From: [Dan Thompson](#)
To: [Deb Estrada](#)
Subject: Re: Public Comment/Notice of Public Hearing – File No. SUB19-002/ (SEP19-005) January 24, 2024/
Date: Tuesday, January 23, 2024 3:42:08 PM

Please consider these my public comments and testimony requesting that the hearing examiner **reject** the city planning department's recommendation for approval for a 14-plat subdivision.

"The Applicant, in response to the public comments received during the SEPA appeal period (Exhibit 12), which ended April 5, 2023, with no appeals filed of the determination of nonsignificance, revised the proposed development (Exhibit 5) by adding an internal shared driveway to serve lots 3, 4, 11, 12, 13, and 14, added a shared driveway for lots 1 and 2, and provided a passive open space easement along West Mercer Way, SE 28th Street, and SE 30th Street that will be planted with native vegetation".

REPLACEMENT TREES

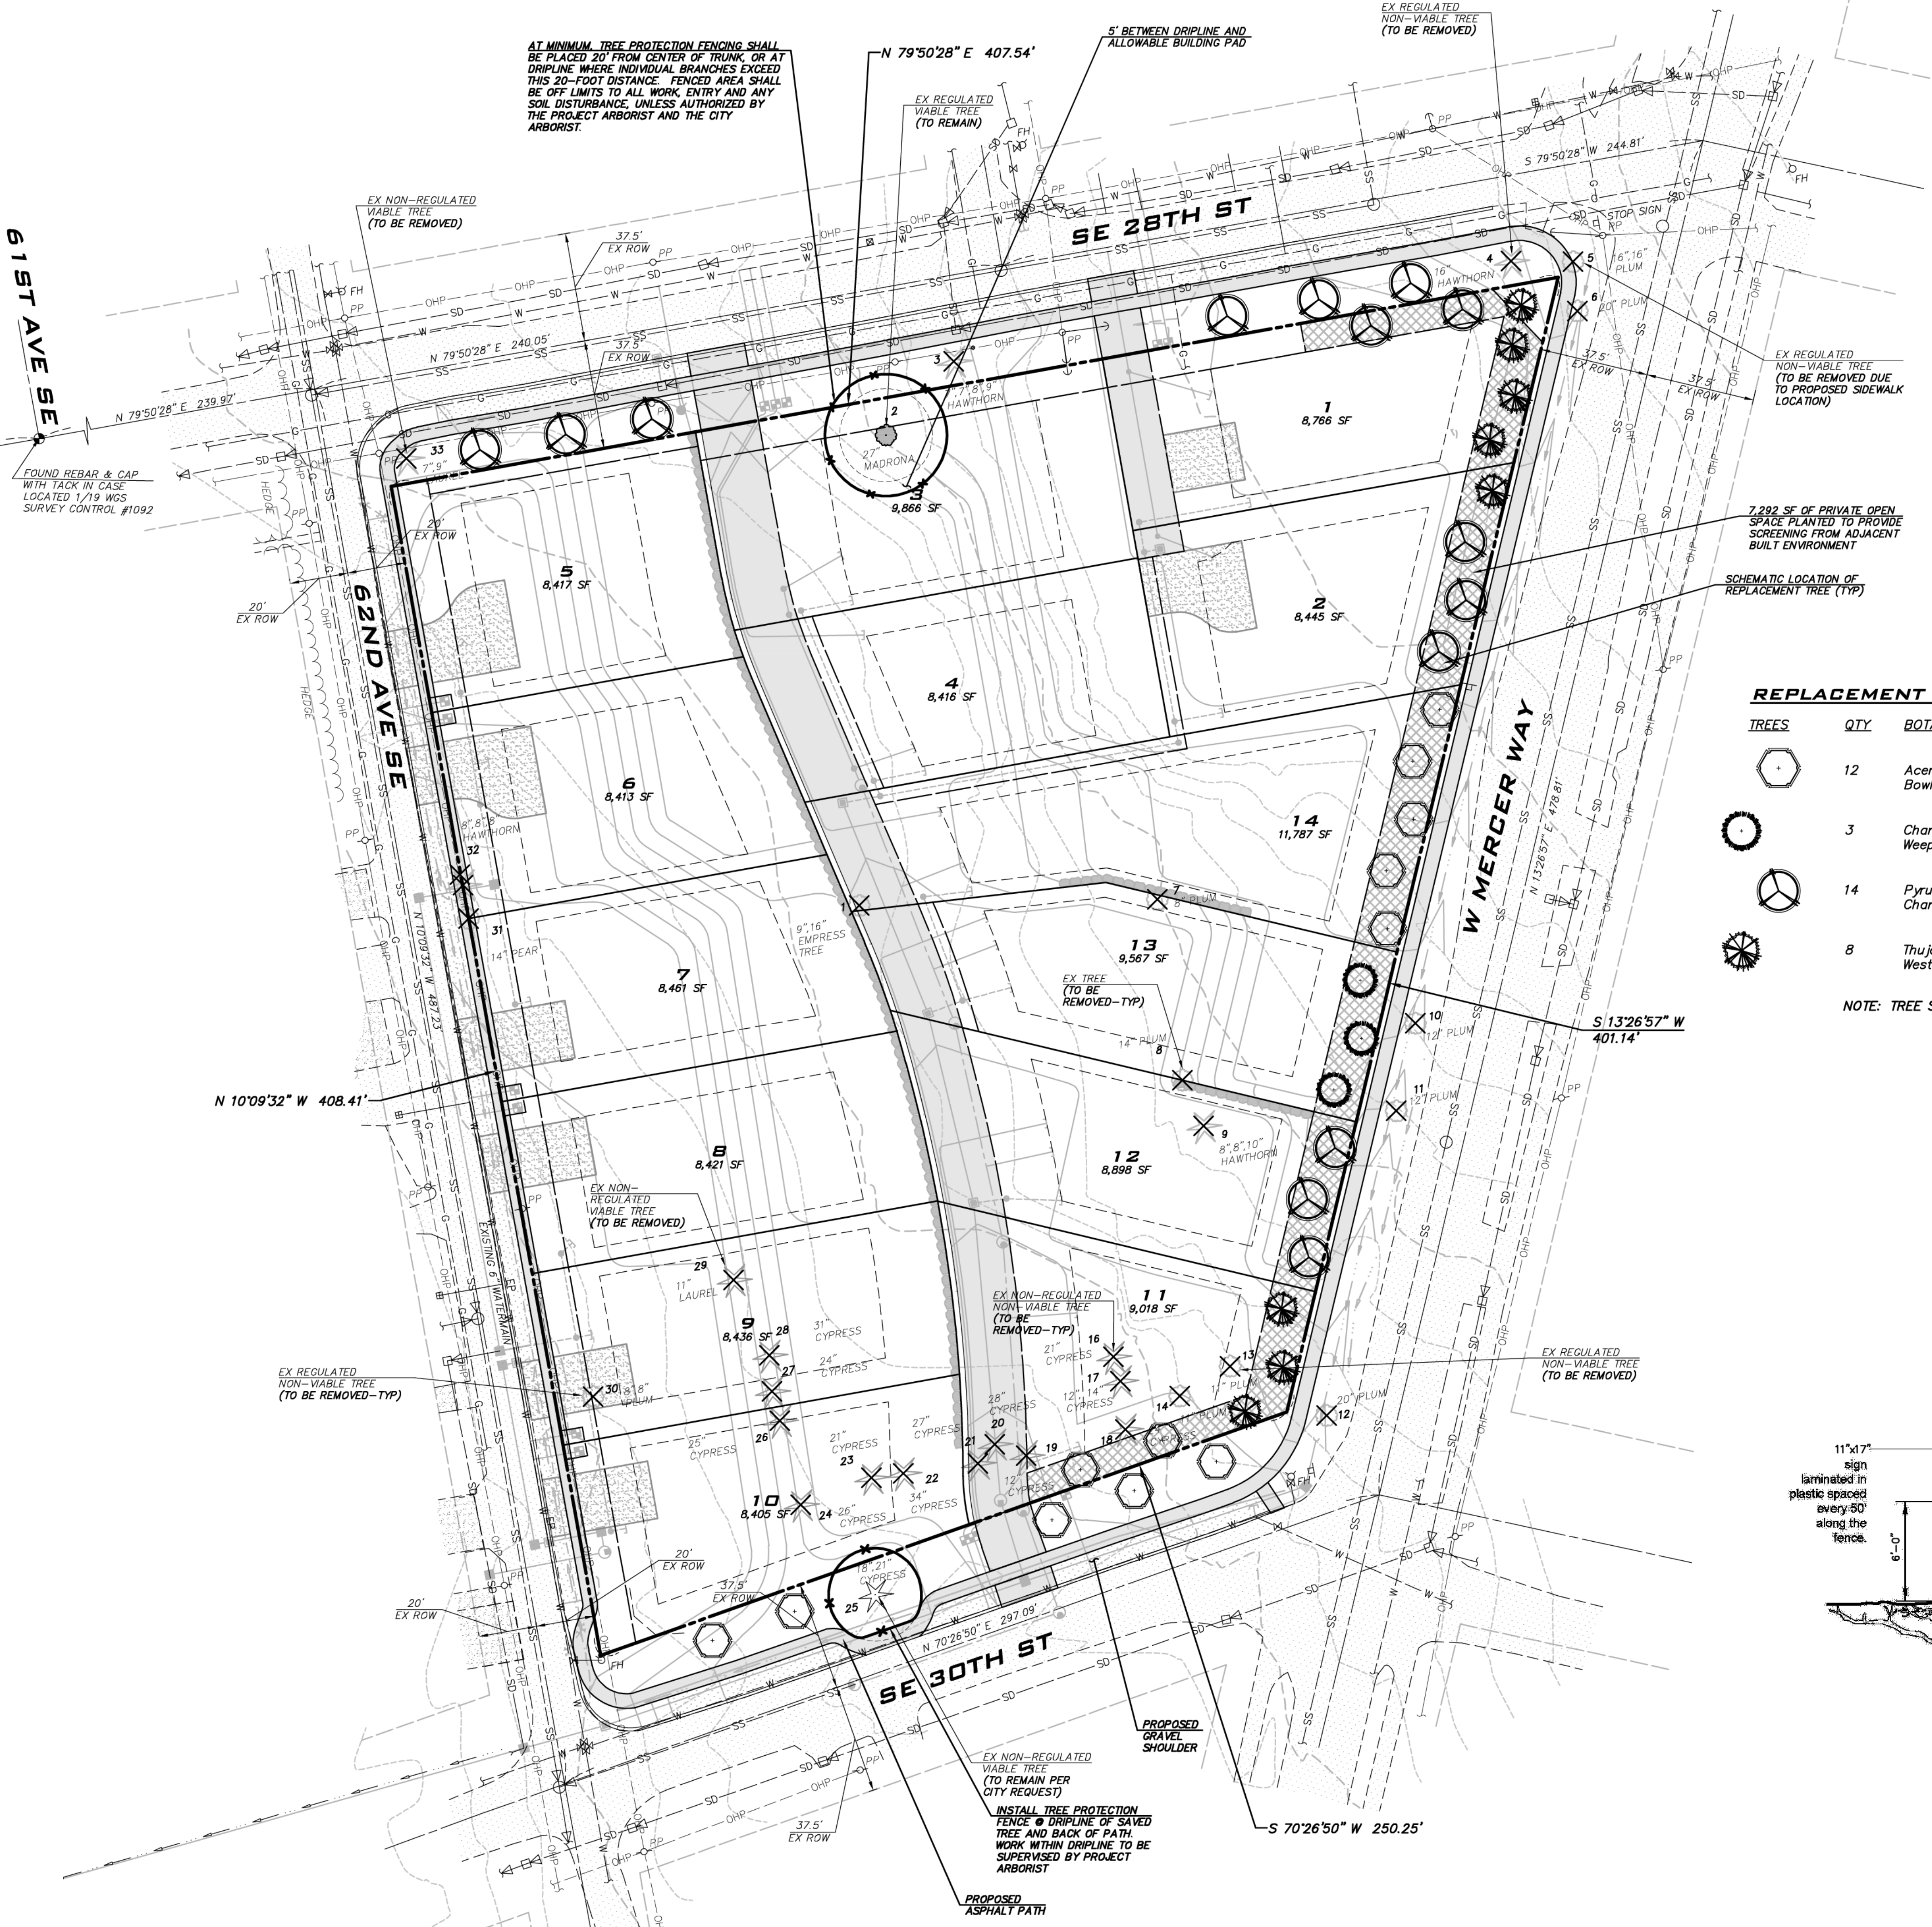
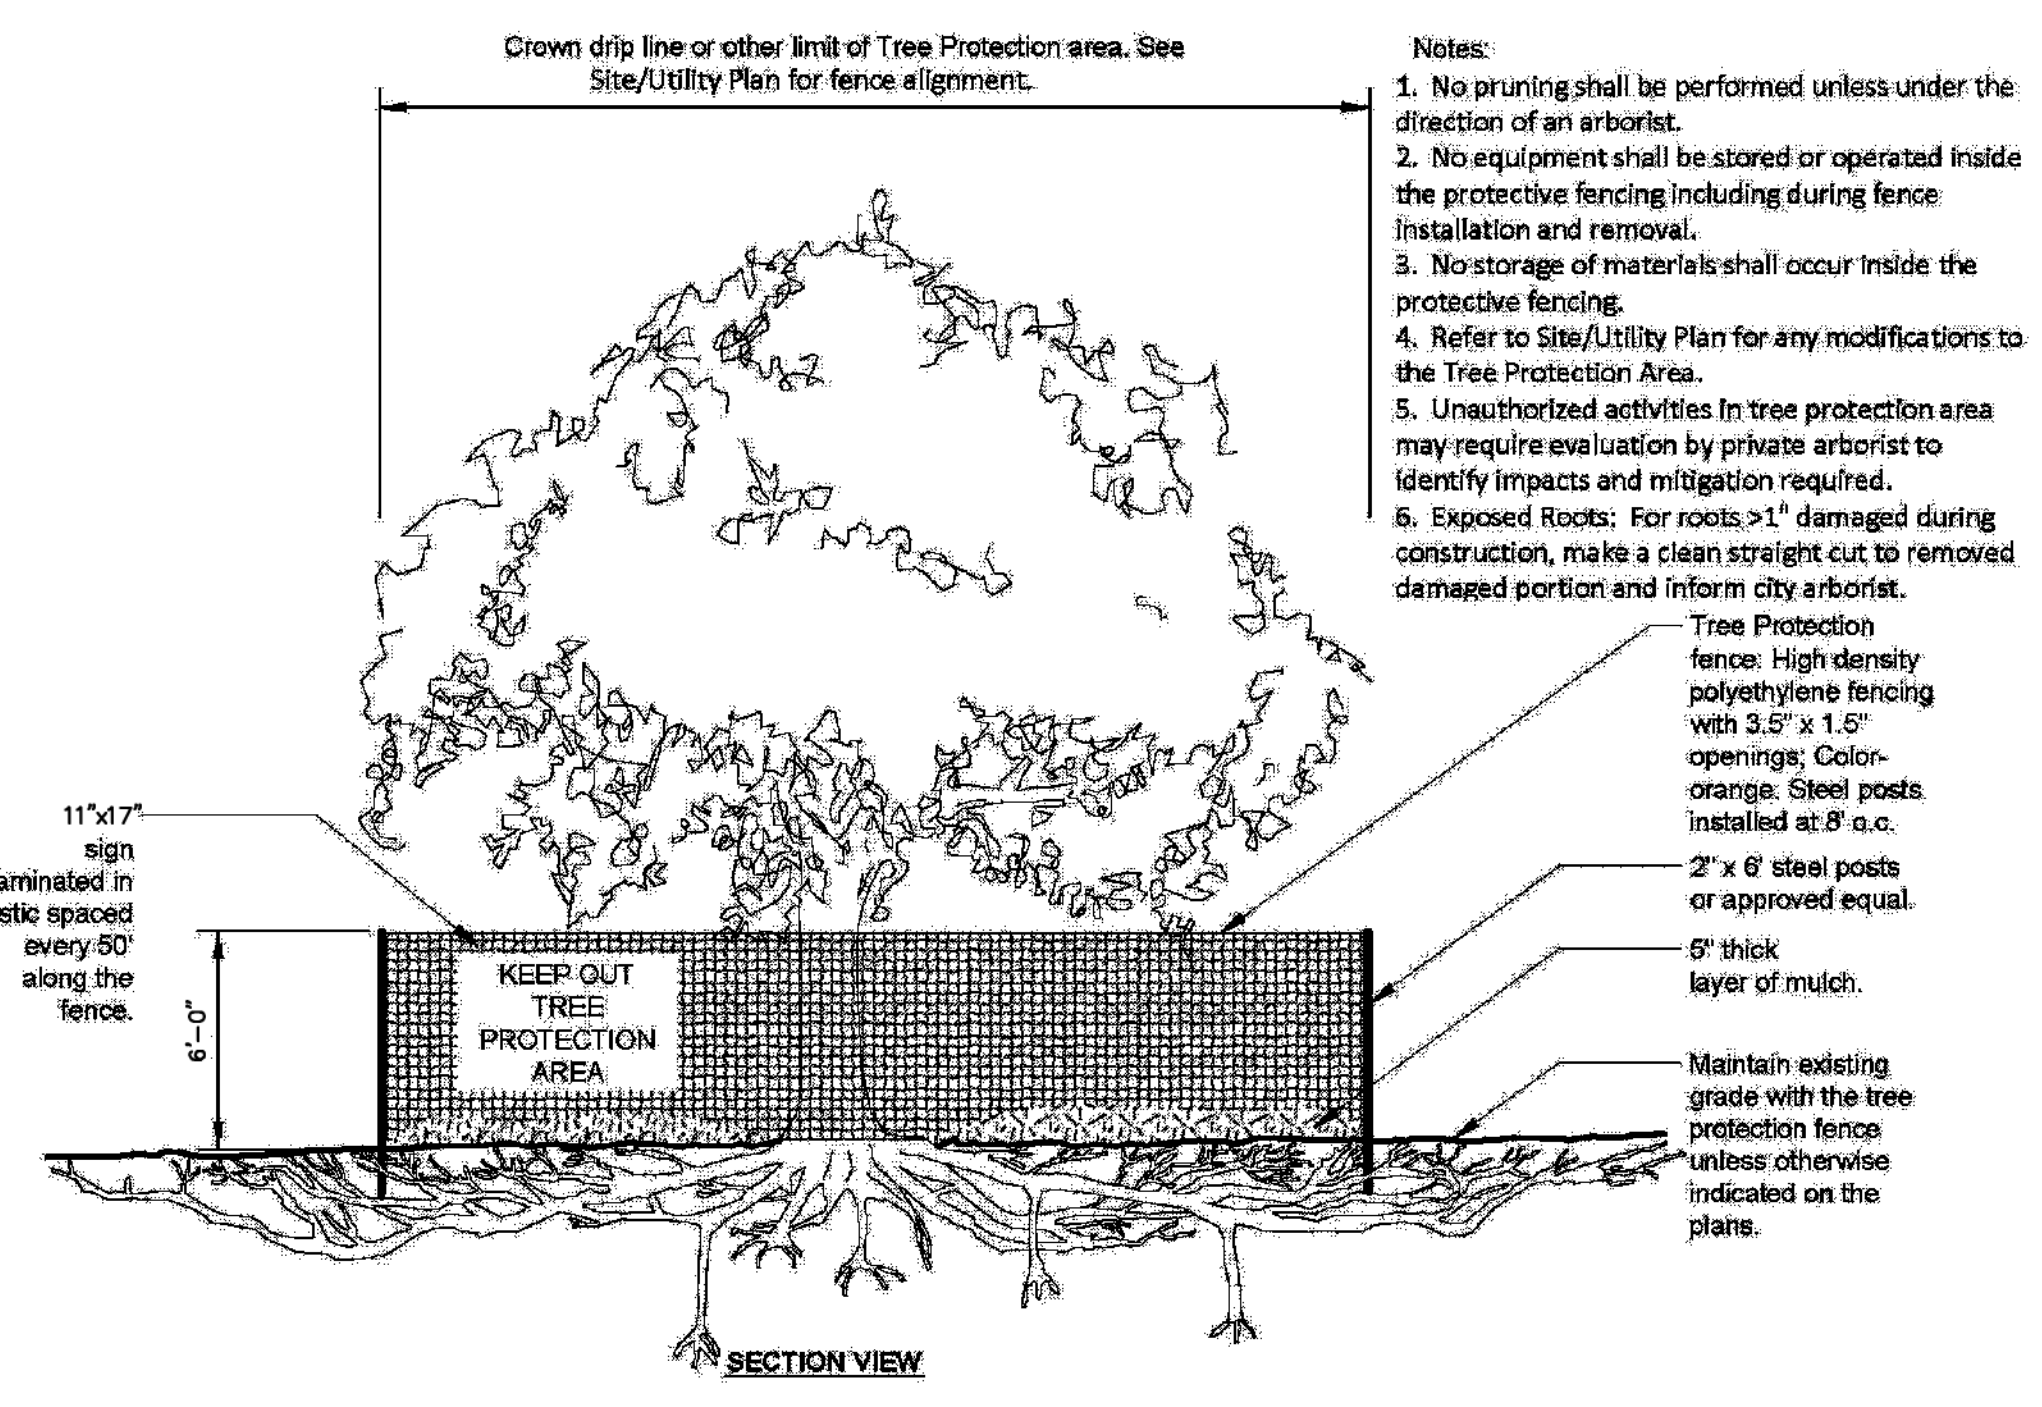
11. Any Tree Removal Should Be Reserved Until The Actual Building Permit Applications Are Submitted. Approving Removal Of 36/37 Trees At The Preliminary Approval Stage Is Contrary To The Mercer Island Tree Ordinance Regulating Tree Removal During Development.

The city's recommendation is in error in accepting the claim 16/17 regulated trees that have existed on the site for decades are suddenly diseased. A regulated tree is a tree with a diameter of 10" or greater. The original reason the applicant's arborist gave in 2019 for removing 36/37 trees in the prior application was they were leaning against the building WHICH THE OWNER HAS TORN DOWN, or would be disturbed by removing the foundation. Now the applicant claims 16/17 regulated trees are suddenly diseased and must be removed, along with 21 other trees with diameters over 20", even though the applicant's arborist never stated this in 2019.

Now, even BEFORE any building permit applications have been filed for each plat the city is giving the developer a green light to remove 36/37 trees from the entire site without any city review, exactly what we fought to prevent, and what the code prohibits.

- A. Provide adequate open/park/recreational space onsite consistent with the findings in Coval.
- B. Extend the internal access road to serve all lots.
- C. Reserve until actual building permit applications are filed for each plat the decision whether to allow removal of any tree under the MICC and tree ordinance.
